From: planning.scanning@york.gov.uk
Subject: FW: 21/00010/FUL 48 White House Gardens Prof. James W. B. Moir OBJ

We'd like to register some particular concerns regarding the proposed extension building at 48 White House Gardens.

1 Rear Elevation
024 Scale: 1:100

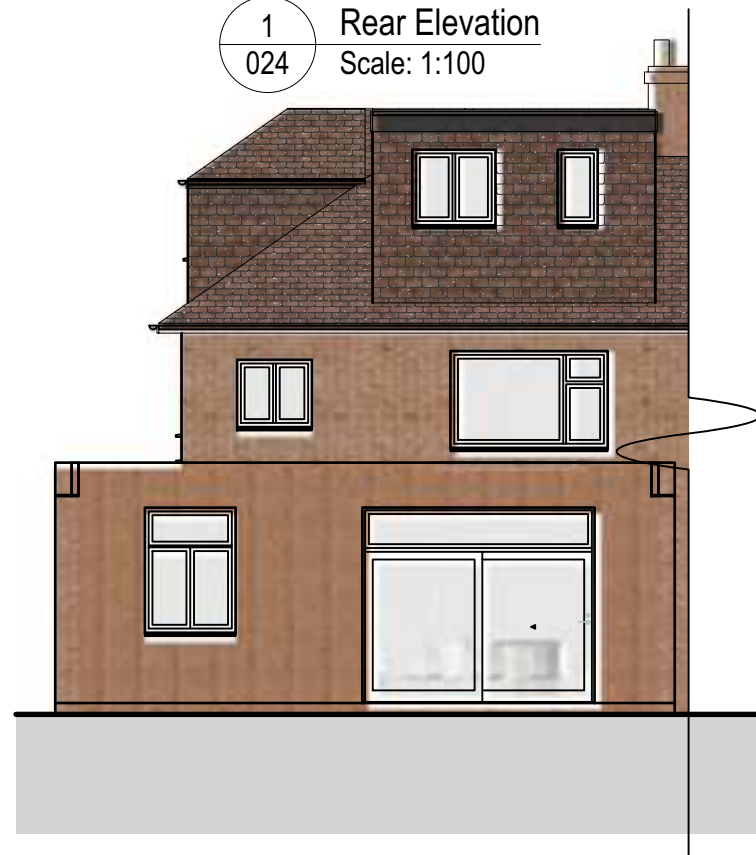
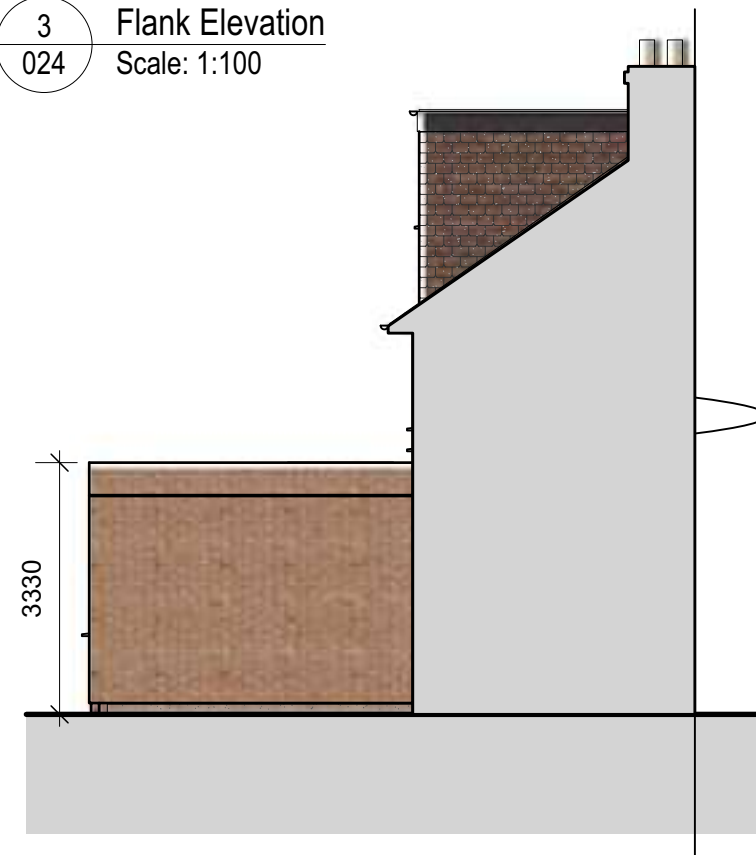
The proposed extension is 3.33 m tall and 4.3 m long (3.985 m internal dimension beyond the back of the original build, plus a presumed 0.30 m for walls). This single storey build would run up to the boundary with our attached property (number 50). If built, the scale and proximity would cause an excessive and permanent loss of natural light and open aspect in our living room, as well as replacement of an open aspect (trees and sky) with a brick wall through our North-facing kitchen / dining room window.

We understand our neighbours wanting to extend their house, and hope that a compromise design and build can be found. With respect to the current build, we object to the excessive height and length. It is our understanding that an extension built within 2 m of a neighbouring property should normally be no higher than 3 m. This could easily be achieved. The internal height of the proposed extension is 2.583 m, which could be reduced by 30 cm or so to bring this within the normal maximum height for a single storey extension (note: the (perfectly reasonable) height of the ceiling in the kitchen at number 50 is 2.28 m). In addition, there may be ways to reduce the depth associated with the flat green roof, to reduce the build height.

It would be reasonable if the length of the extension adjacent to our house went 3 m back from the original build, but the currently proposed 4.3 m would loom over our property and make our living room dark through the day time. It would be out of scale with the size of property, taking up a significant proportion of the garden. A 3 m extension, as would be a permitted development, is much more reasonable, and in keeping with the size of the properties and their gardens, hereabouts.
